Application No: EP/35/22/HH
Site Address: West House South Strand East Preston BN16 1PN
Description of works: Erection of single storey front extension, first floor front/side extension and alterations to fenestration/openings.

This council's Planning & Licensing Committee considered this Application at its meeting on 25th April. The applicants were invited to attend but did not do so.

E ELEV

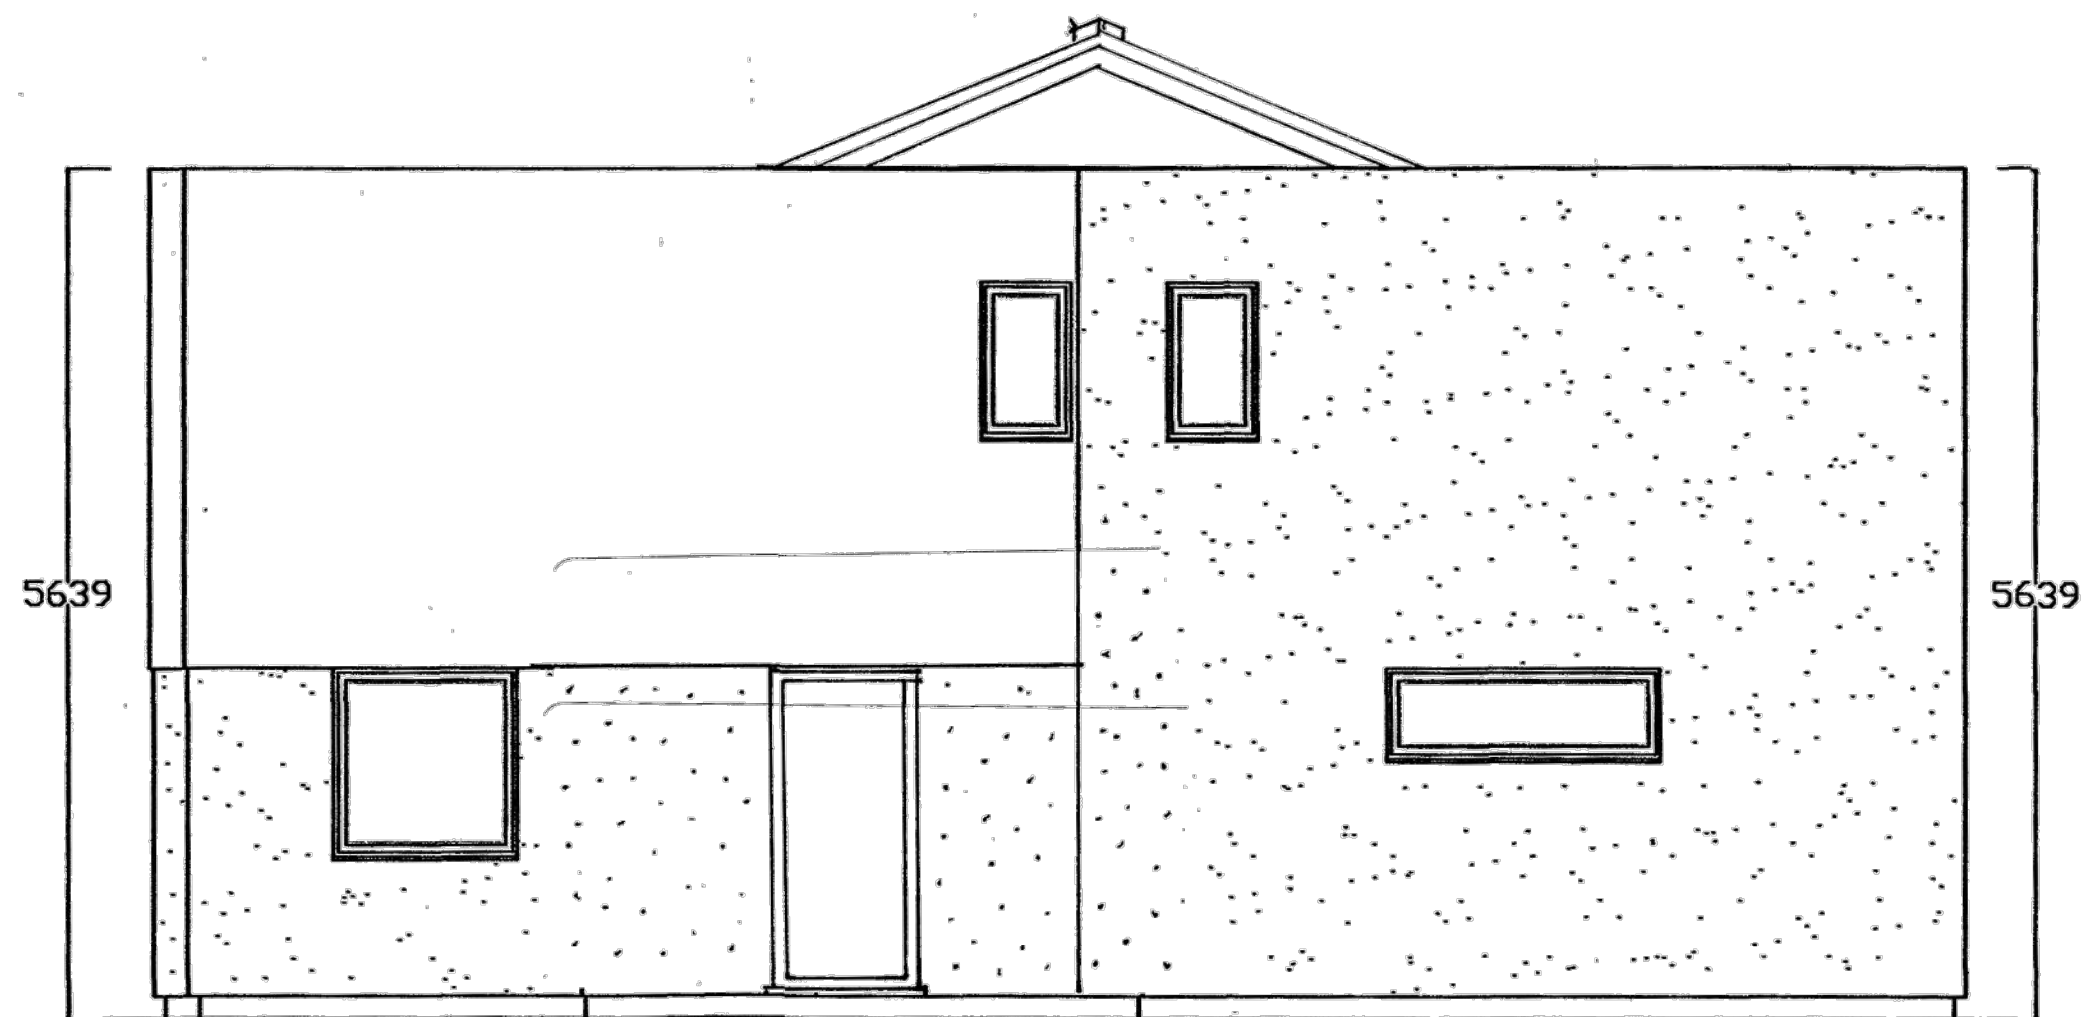
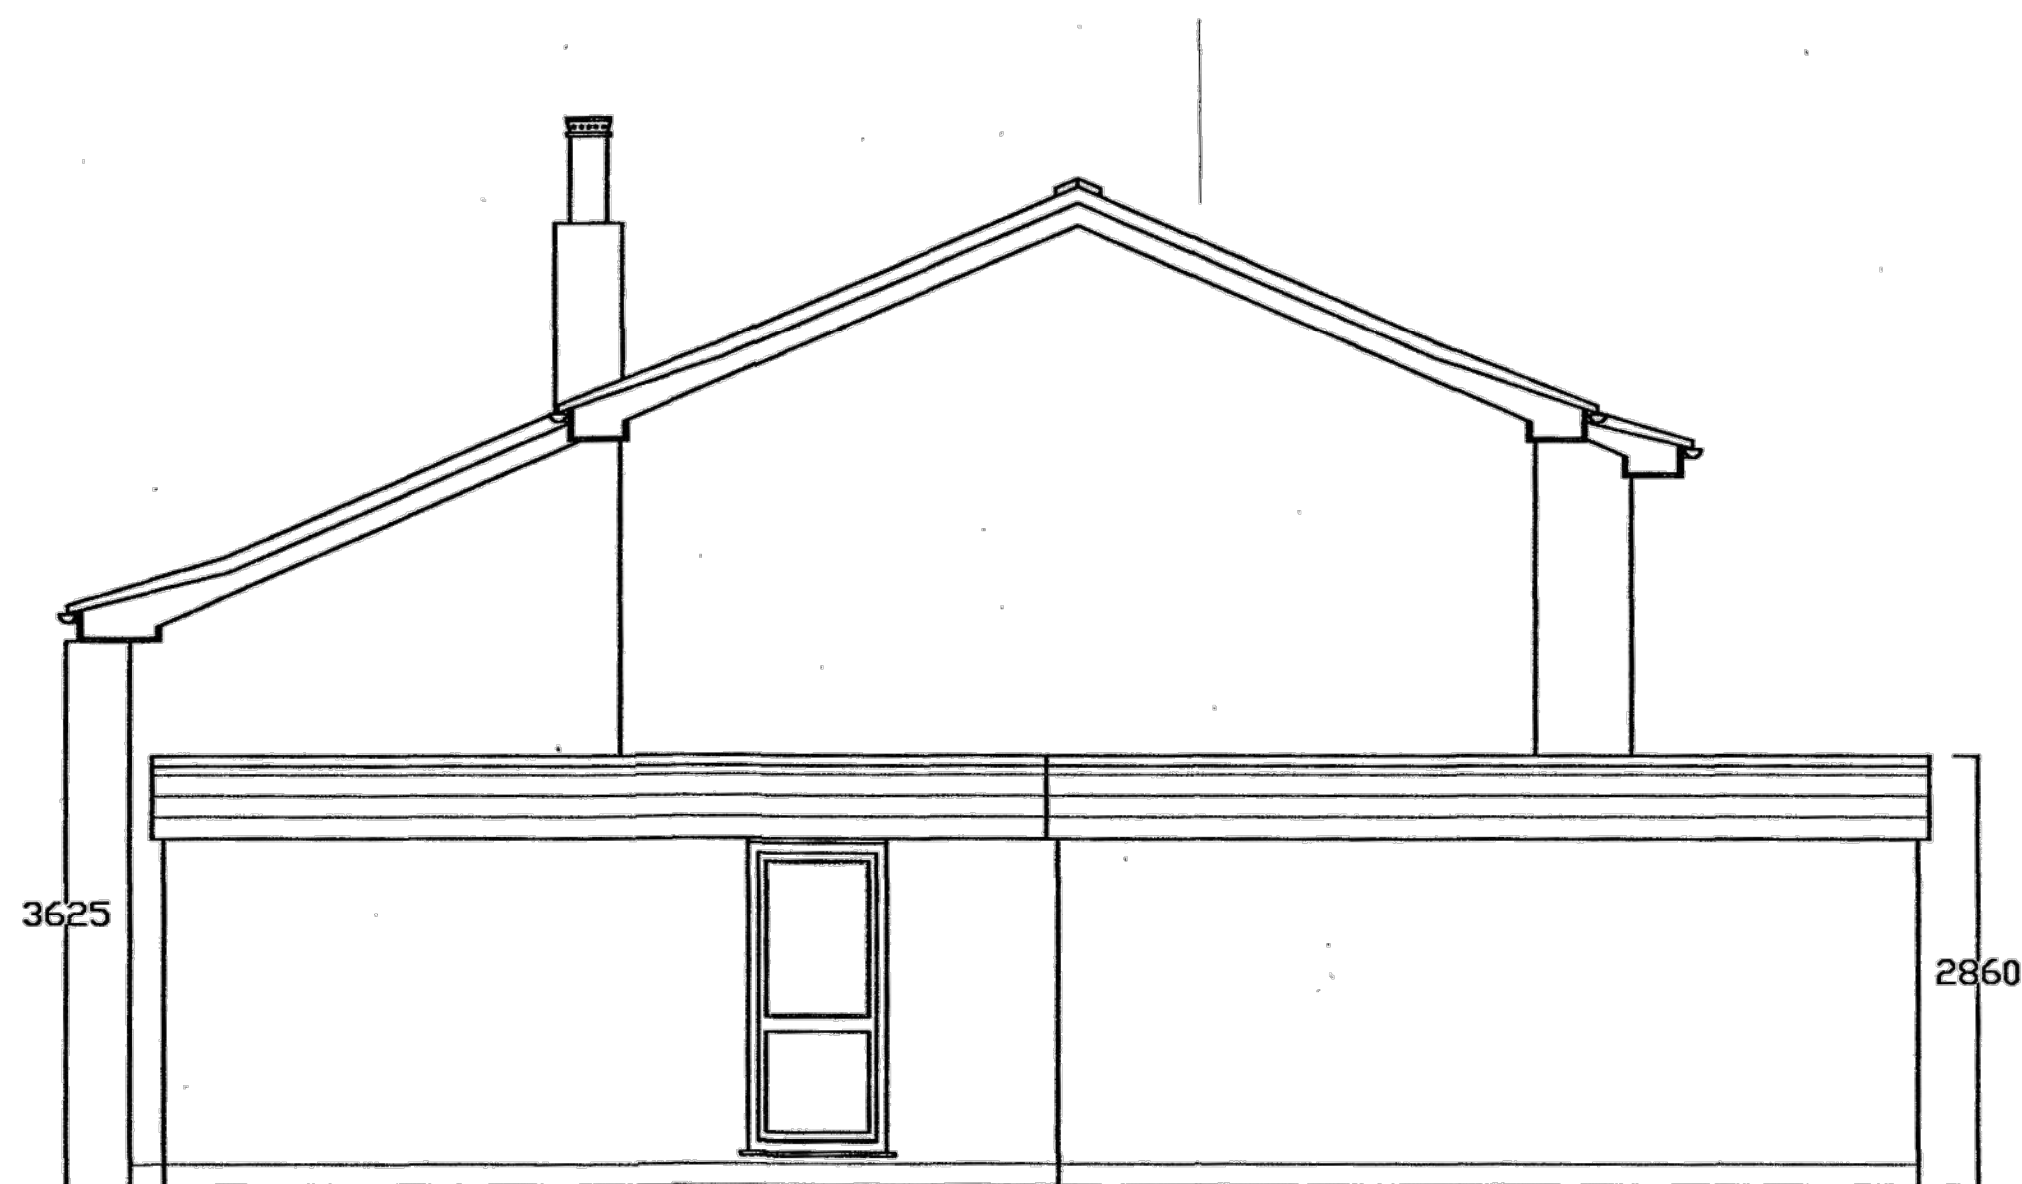
The committee remained concerned the proposed first-floor extension is not well integrated into the existing building. This will be very visible from the north and could be deemed to change the streetscene in South Strand. This extension may also be overbearing towards the property to the east of the application site.

S ELEV

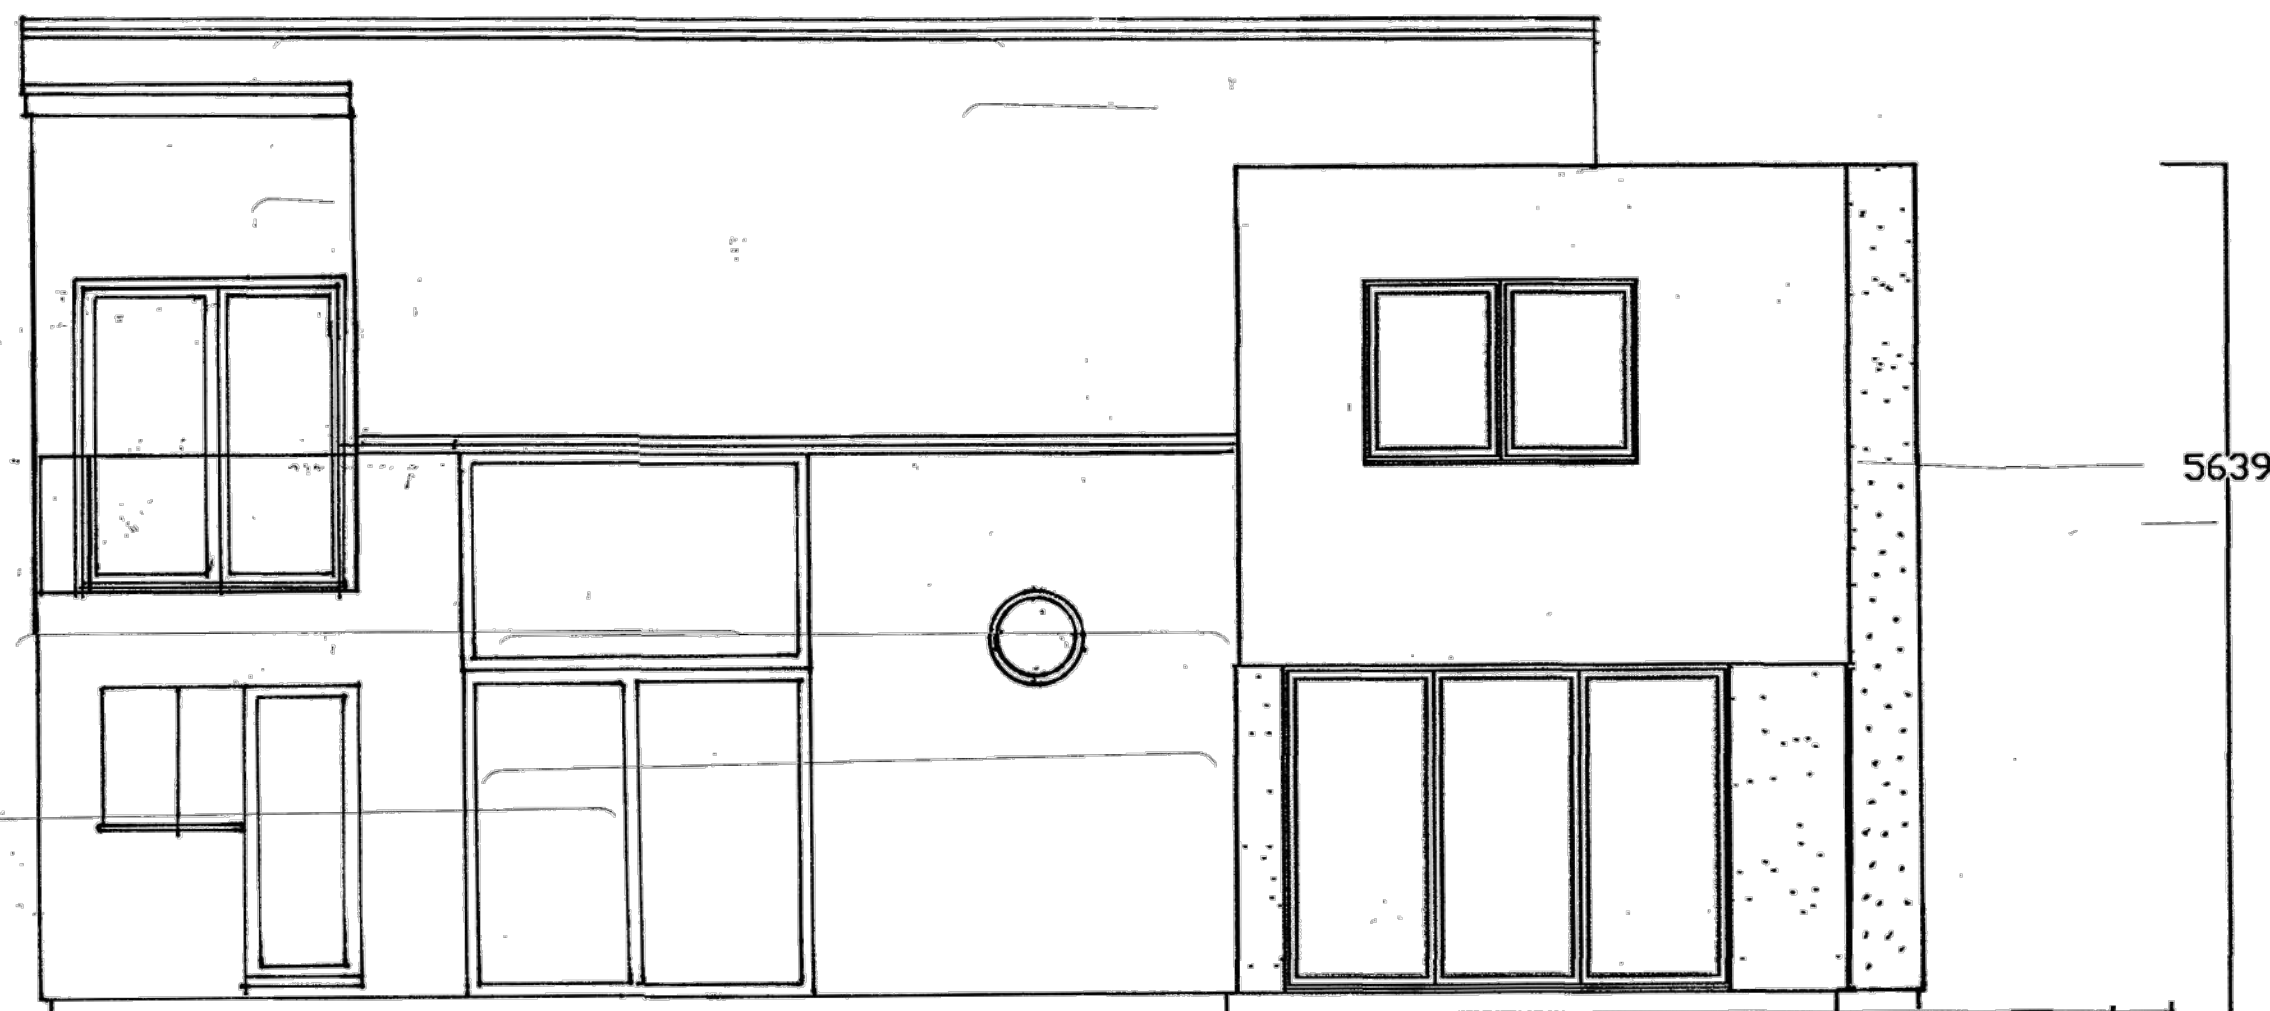
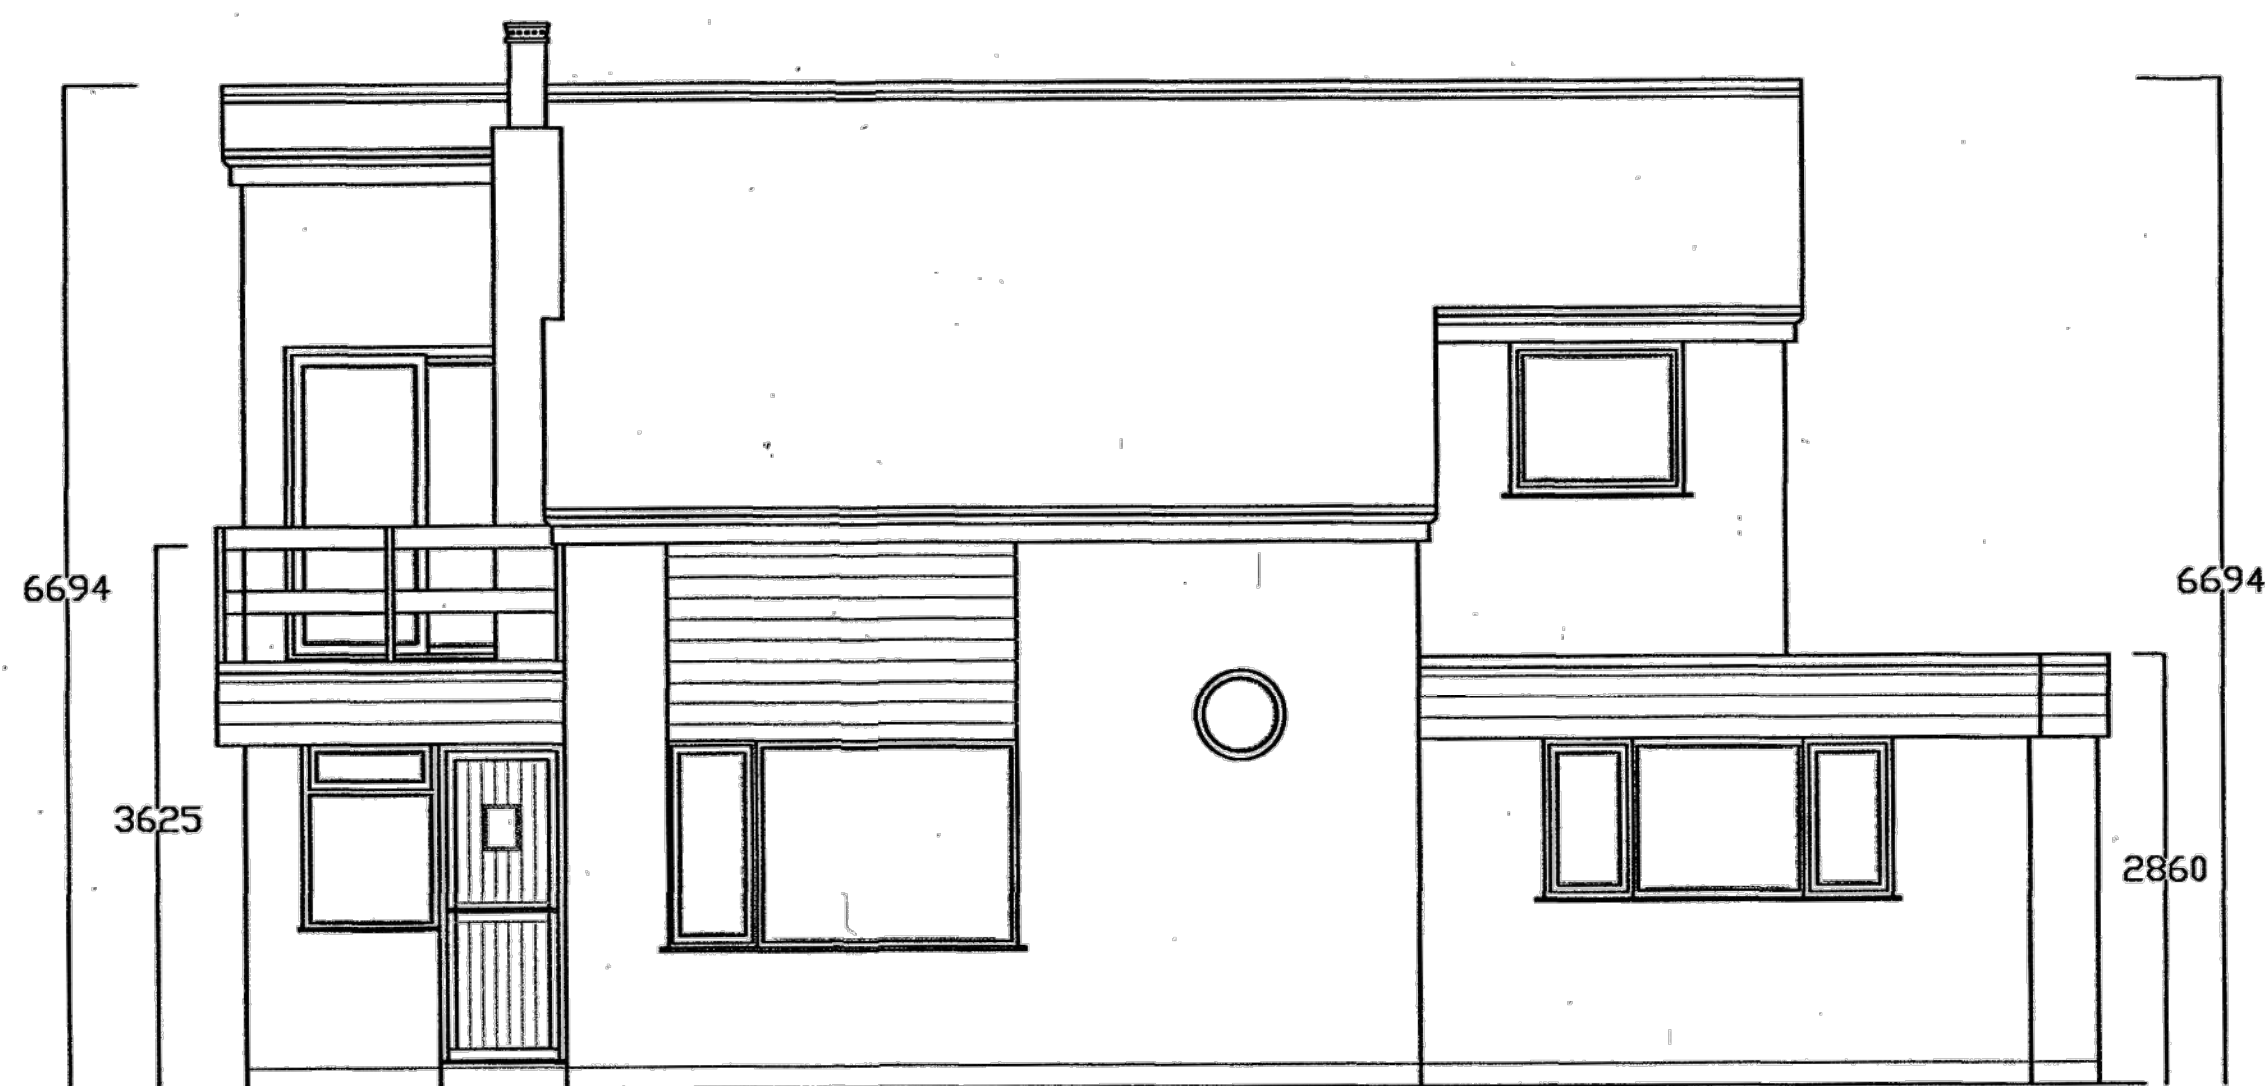
The committee also remained concerned the proposed extension at the south of the building may be too close to the north of the property immediately to the south of the application site. We understand established screening between the two properties has been removed, in the process reducing the mitigating effect that screening had.
